CITY OF ALBUQUERQUE

10/24/2025

Re: Peaches Fitness Club
4805 All Saints Rd. NW Albuquerque, NM 87120
Traffic Circulation Layout
Engineer's Stamp XX-XX-XX (C13-D016D)

DATE: 2/10/2026	SHEET: AS501
SCALE:

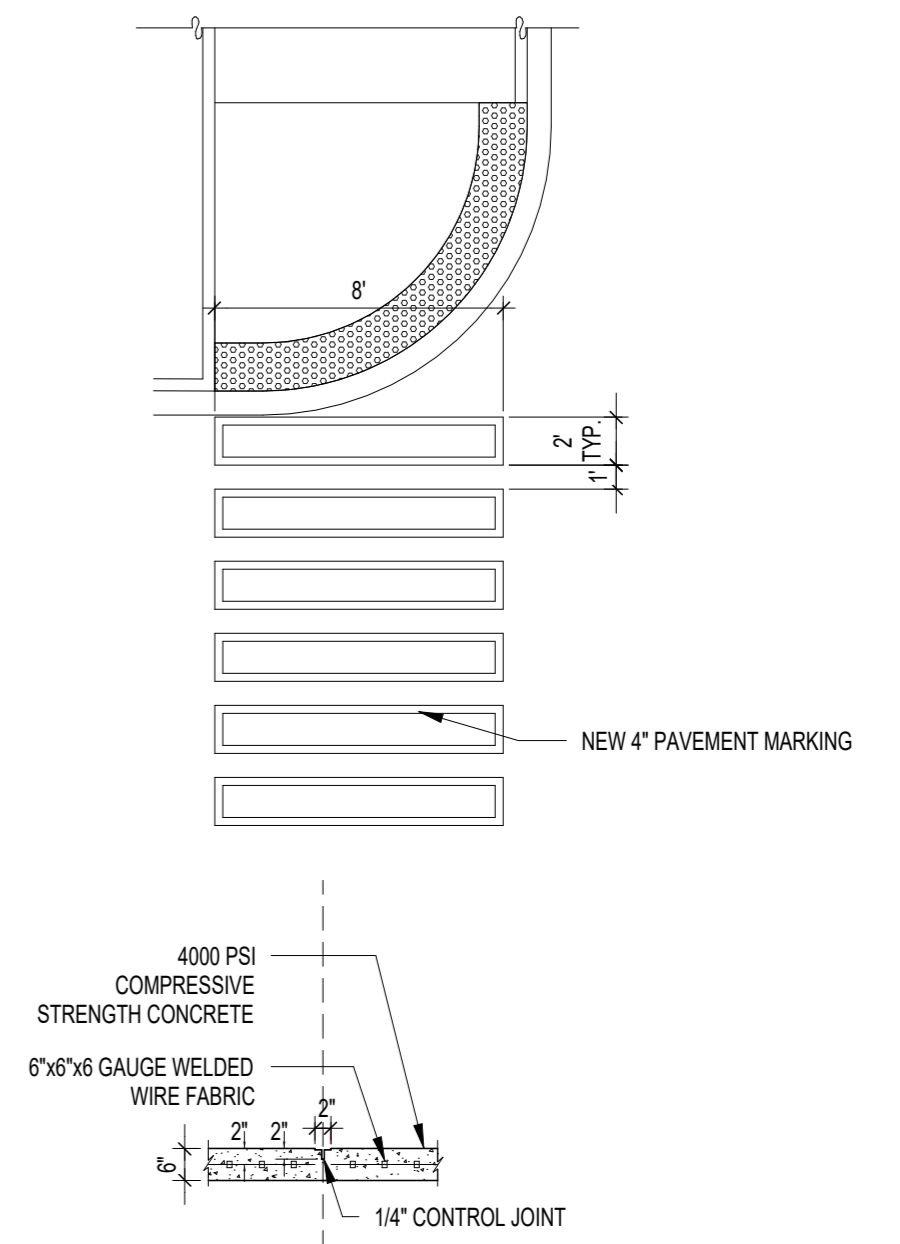
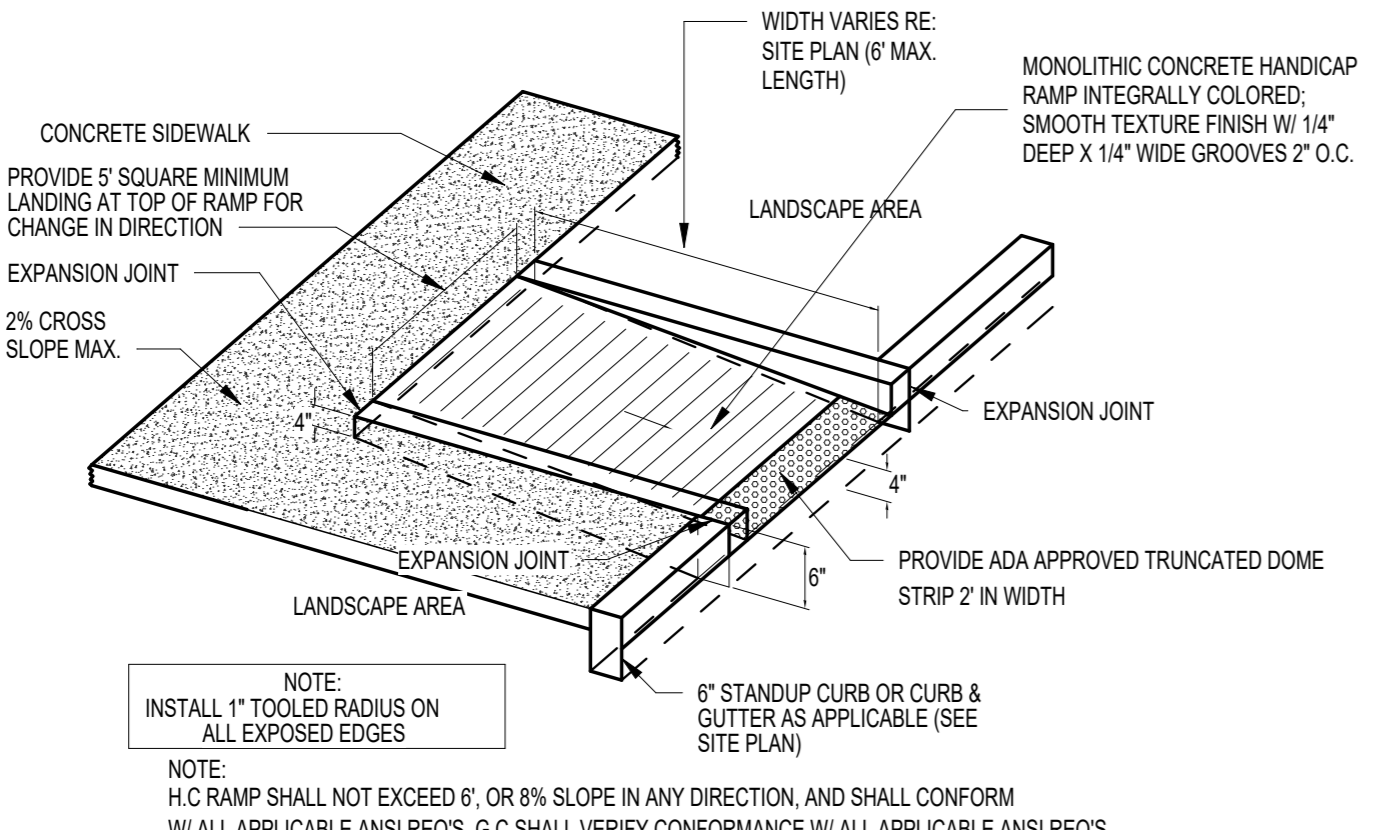
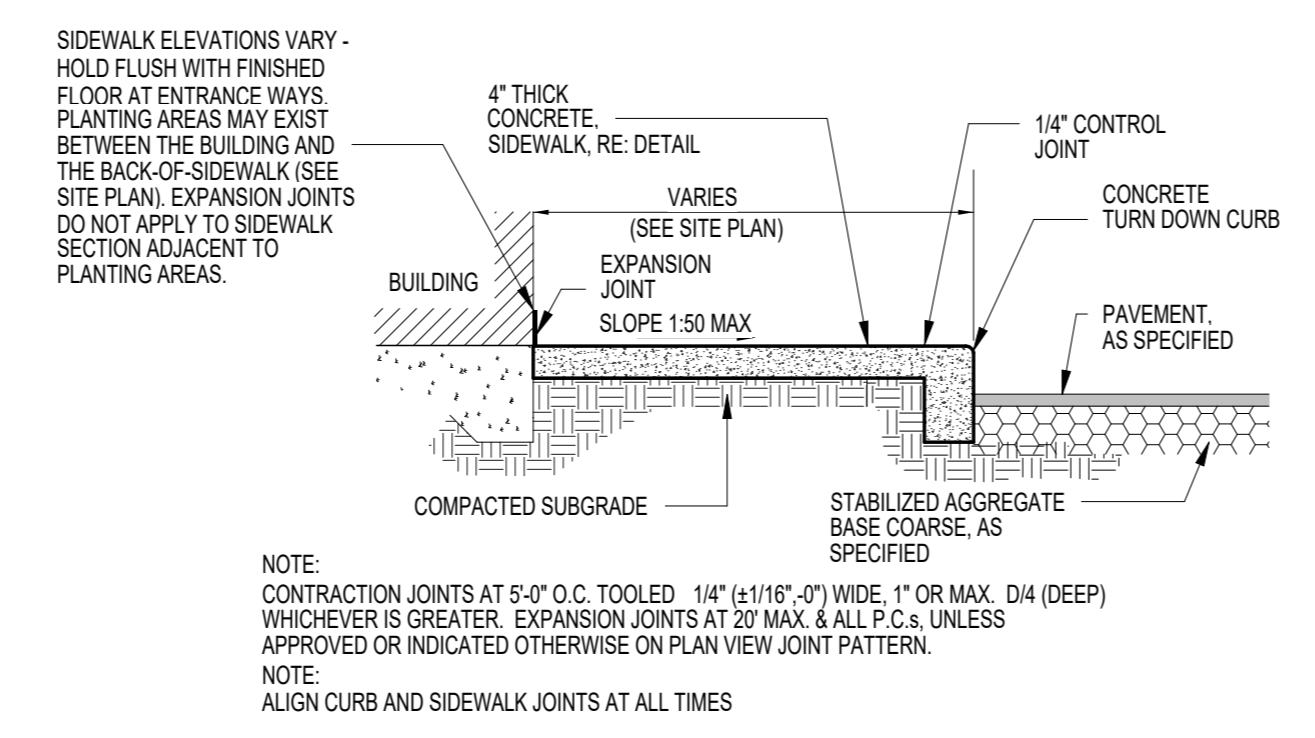
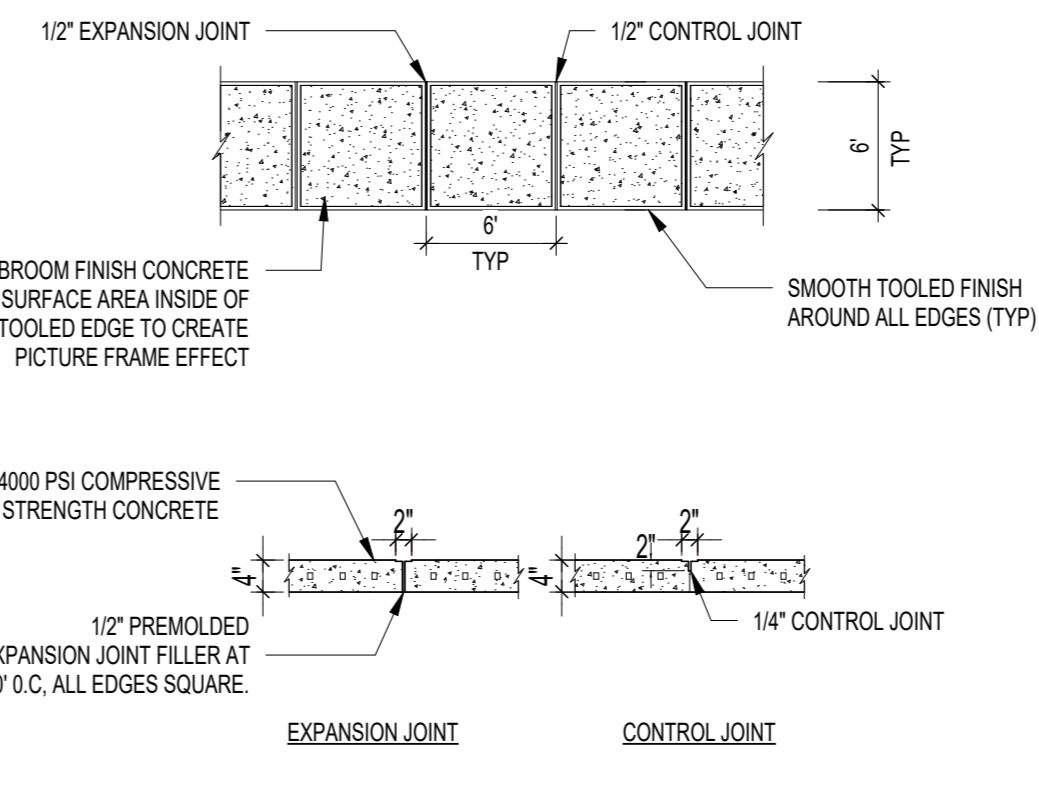
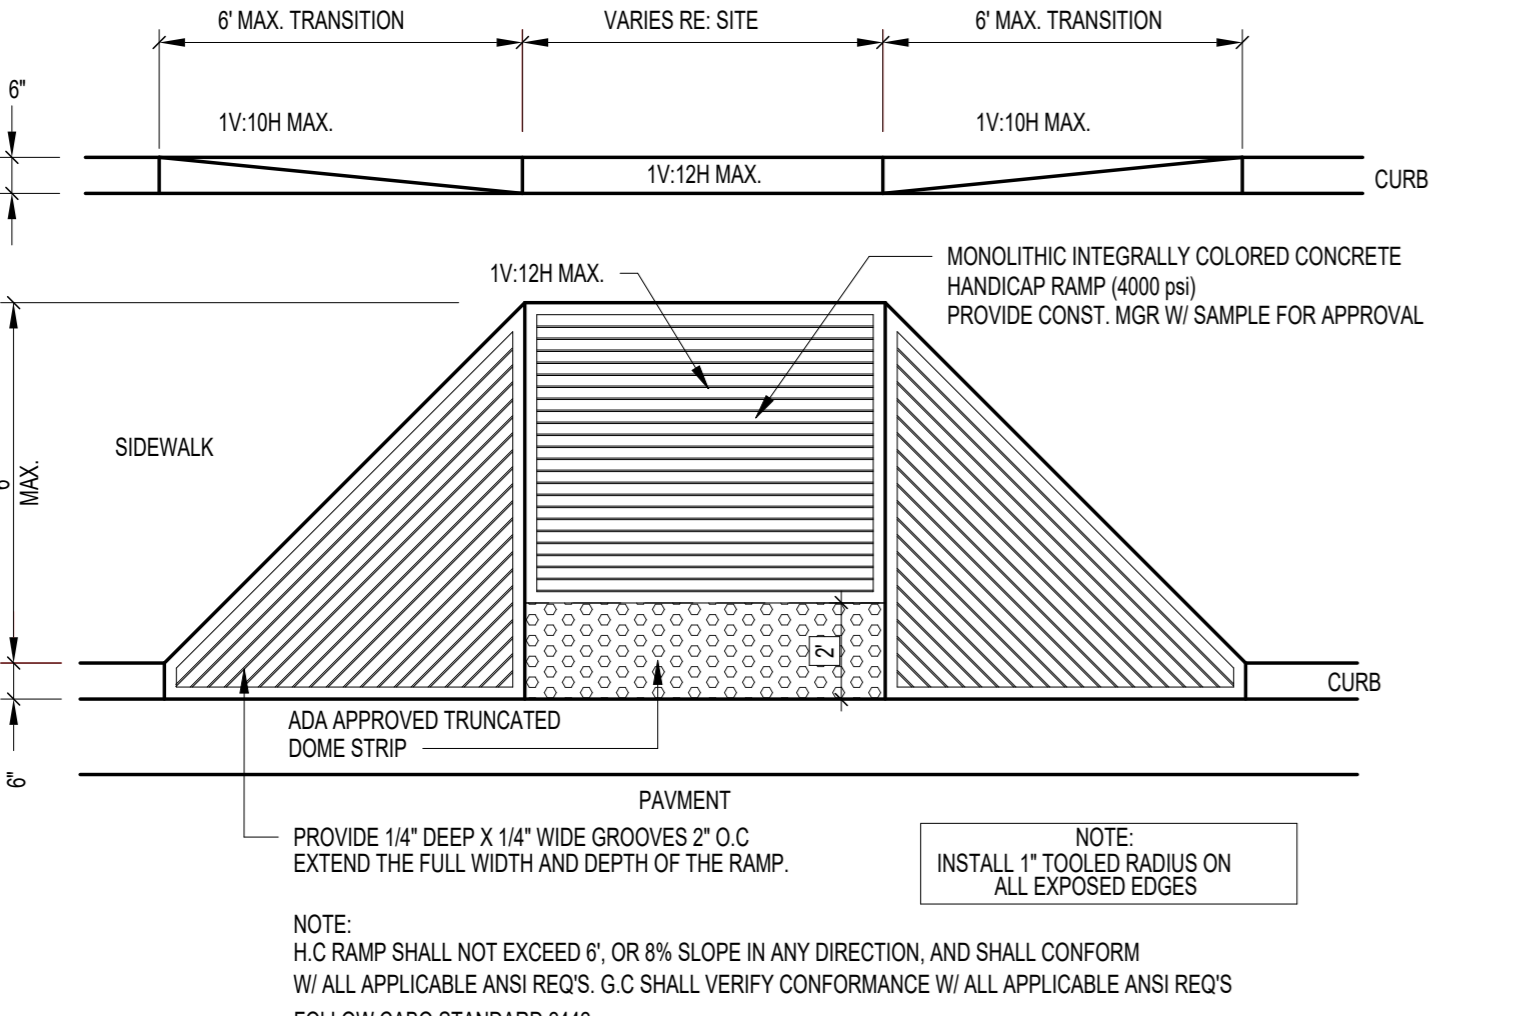
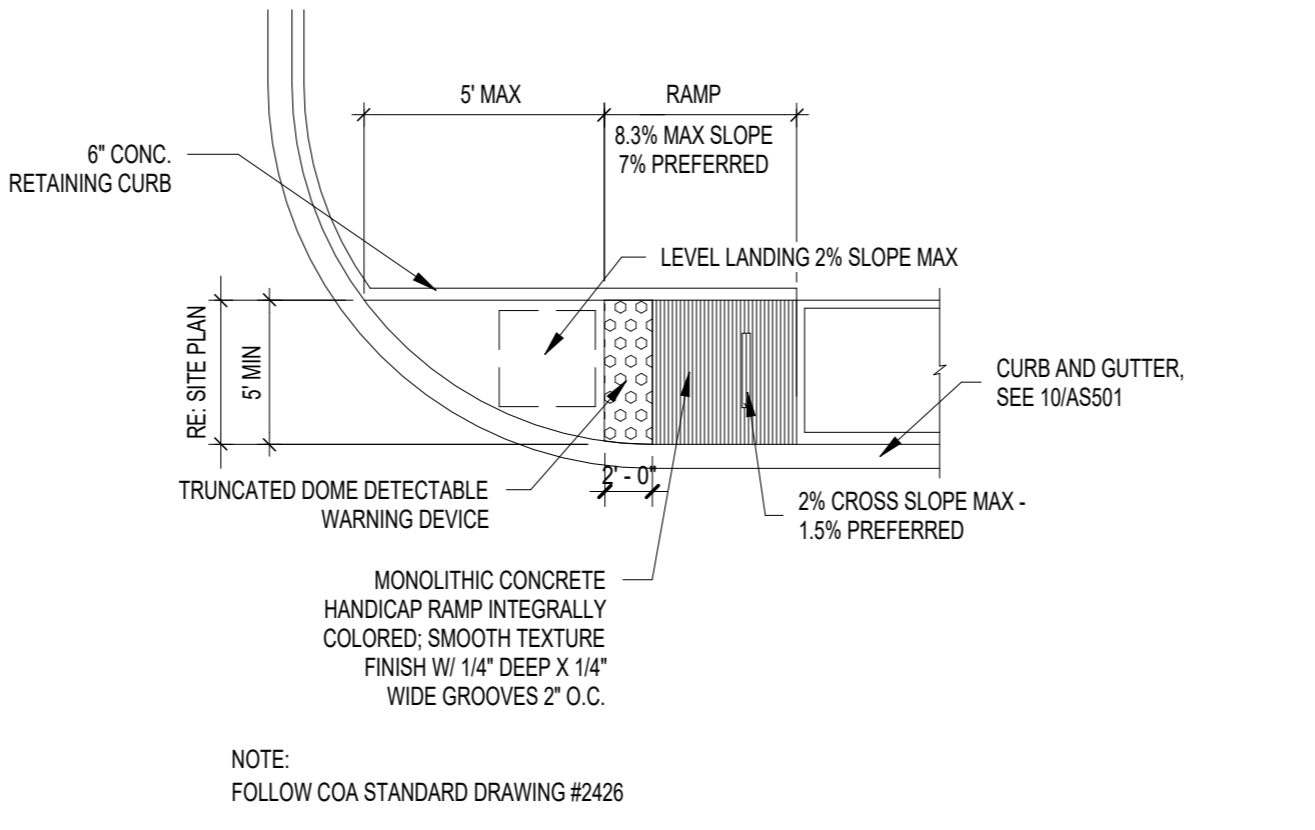
37. Provide City standard drawings and/or detail drawings that reflect design intentions. Where the aisles will function for deliveries by larger trucks, refuse, and/or fire vehicles, etc., a 25 foot radius or larger is to be used.

38. There are some cases of incorrect detail reference call outs. Verify that provided standard drawings reflect design intentions and reference callouts.

DATE 2/10/2026	SHEET AS502
-------------------	-----------------------

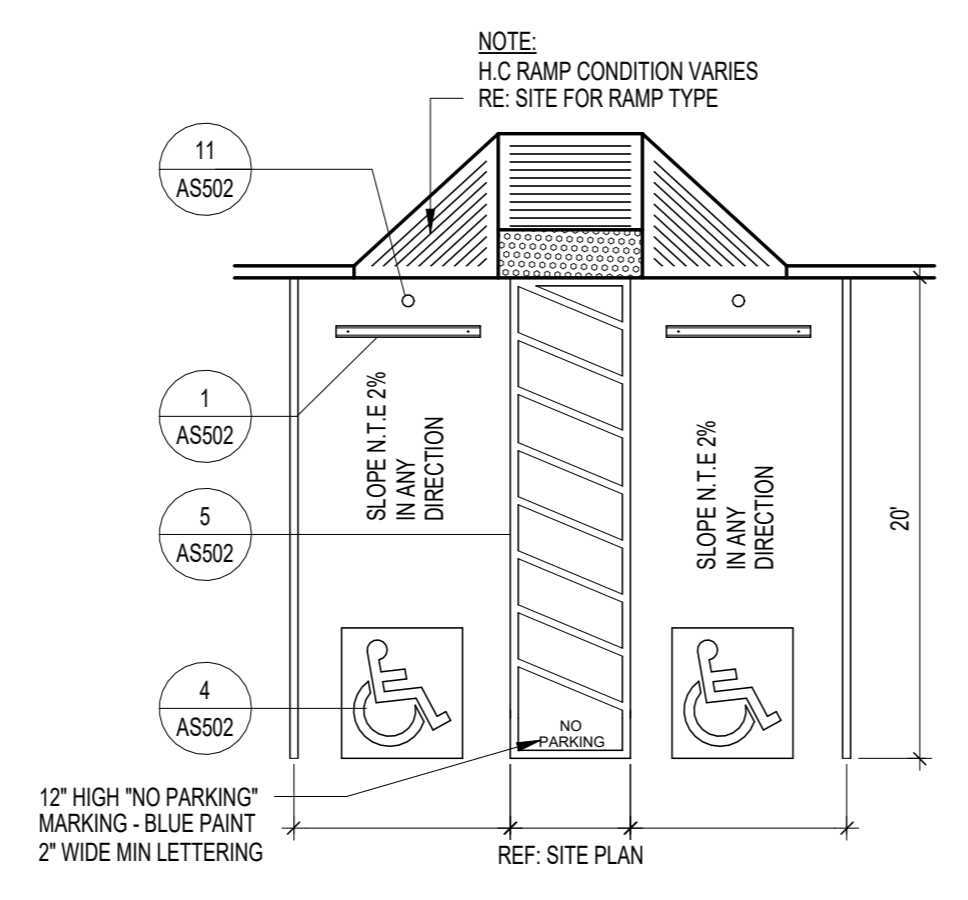
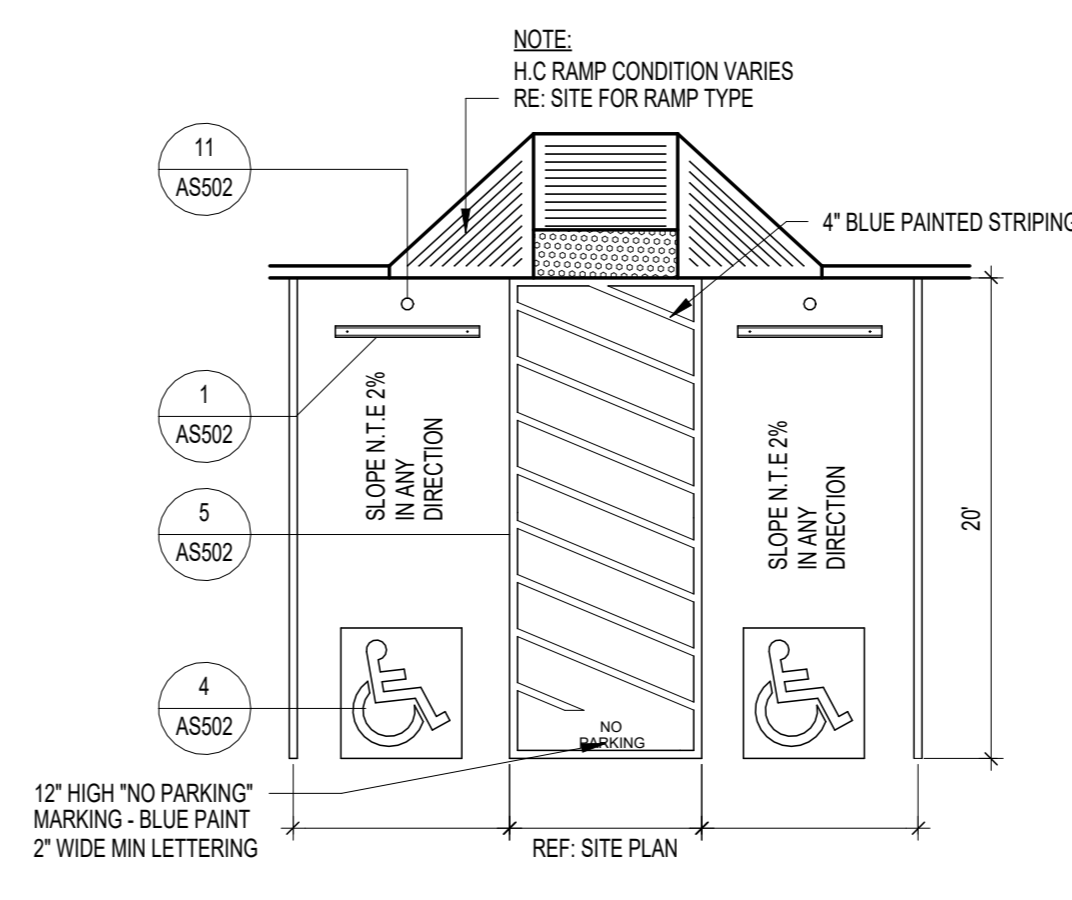
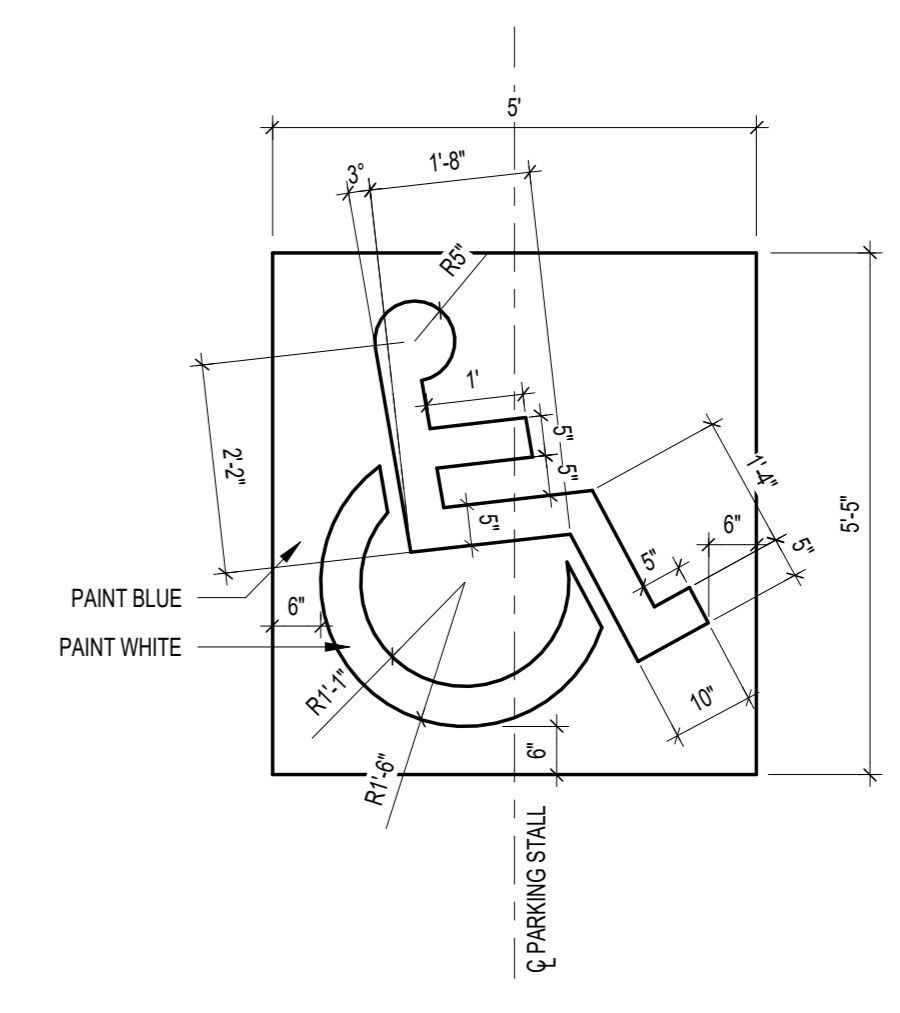
18. Dimensions, design, and stripping on site plan for ADA parking does not match detail drawings 2 and 3, sheet AS502. Please verify and correct as needed.

19. ADA access aisles shall have blue diagonal striping and the words **"NO PARKING"** in capital letters, each of which shall be at least one foot high and at least two inches wide, placed at the rear of the parking space so as to be close to where an adjacent vehicle's rear tire would be placed (66-1-4.1.B NMSA 1978). White paint is called out in detail drawing. Please correct detail drawing as needed.
